PORTLAND MAINE

August 25, 2010

CBL: 125 O003001
Located at 12 CLIFTON ST

Inspection Violations

Second
Floor

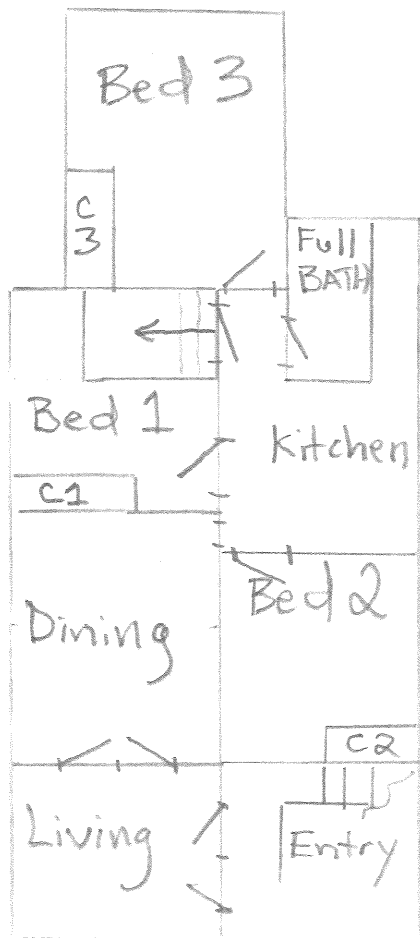
| Notes: On second floor back bedroom a egress window will have to be installed. Window has to have a clear opening of 5.7 sq. Ft. Window cannot be more than 44" off the floor, has to a minimum width opening of 20" and height opening of 24". | | | | | |

Third
Floor

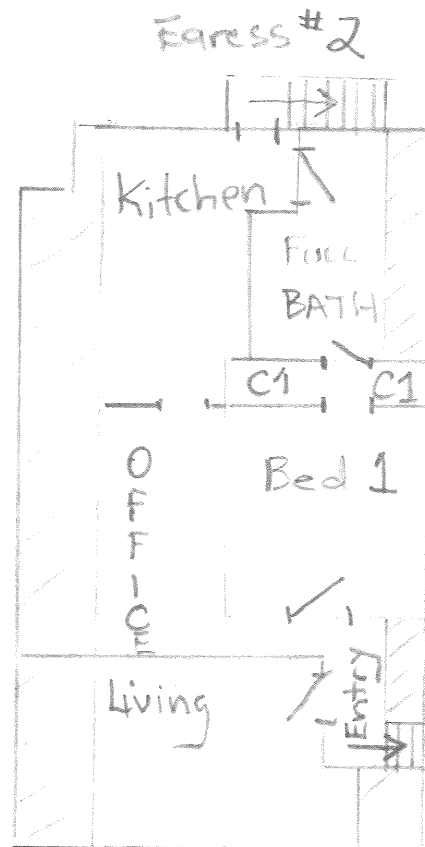
| Notes: Apply for an electrical permit and have a master electrician certify the entire building. Permit shall include installing all interconnected smoke and carbon monoxide alarms per code for entire building. All Kitchens, and Bathrooms need to have a dedicated circuit and GFI protected. The fan in the third floor apartment has to be functional. | | | | | |
| Notes: Third floor fire escape will have to be properly secured to the building. The roof top exit does not have proper fall protection throughout. A guard at 42" continuous from top to bottom has to be installed per city ordinance. | | | | | |
